**MAJOR PROJECT ASSESSMENT  
SUBDIVISION, CONSTRUCTION OF THREE  
8 STOREY BUILDINGS AND BASEMENT  
CAR PARKING**

***Honeysuckle Central, Newcastle  
Proposed by Eureka /Buildev***

***MP08\_0043***

Director General's Environmental Assessment Report  
Section 75I of the  
*Environmental Planning and Assessment Act 1979*

HONEYSUCKLE CENTRAL LANDSCAPE MASTERPLAN

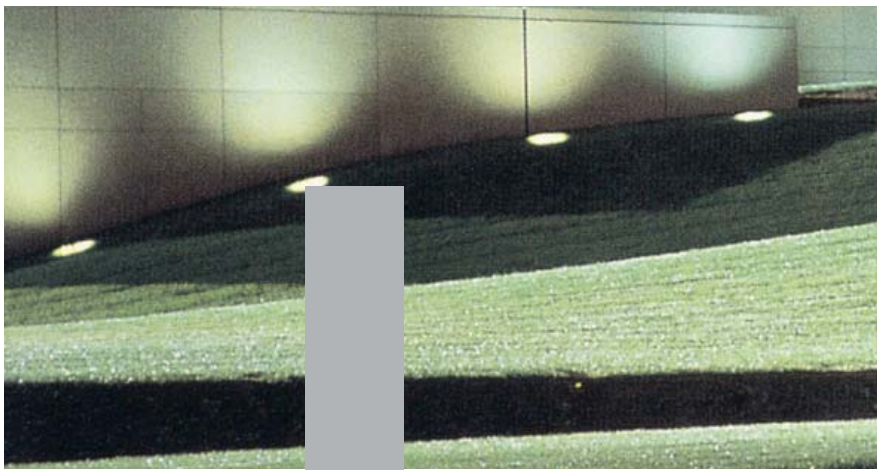
- Design refinements to the northern façade to include individual building elements
- Design refinements to the base element of the southern façades of the 3 buildings to reduce their apparent visual bulk and dominance
- Design refinements to the landscaped areas to reduce the amount of paving or hard surfaces and take greater advantage of the deep soil planting available through the provision of larger scale plantings and also incorporate increased garden areas, subject to accessibility requirements being satisfied
- Honeysuckle Drive to be activated by ground floor retail/commercial service uses.
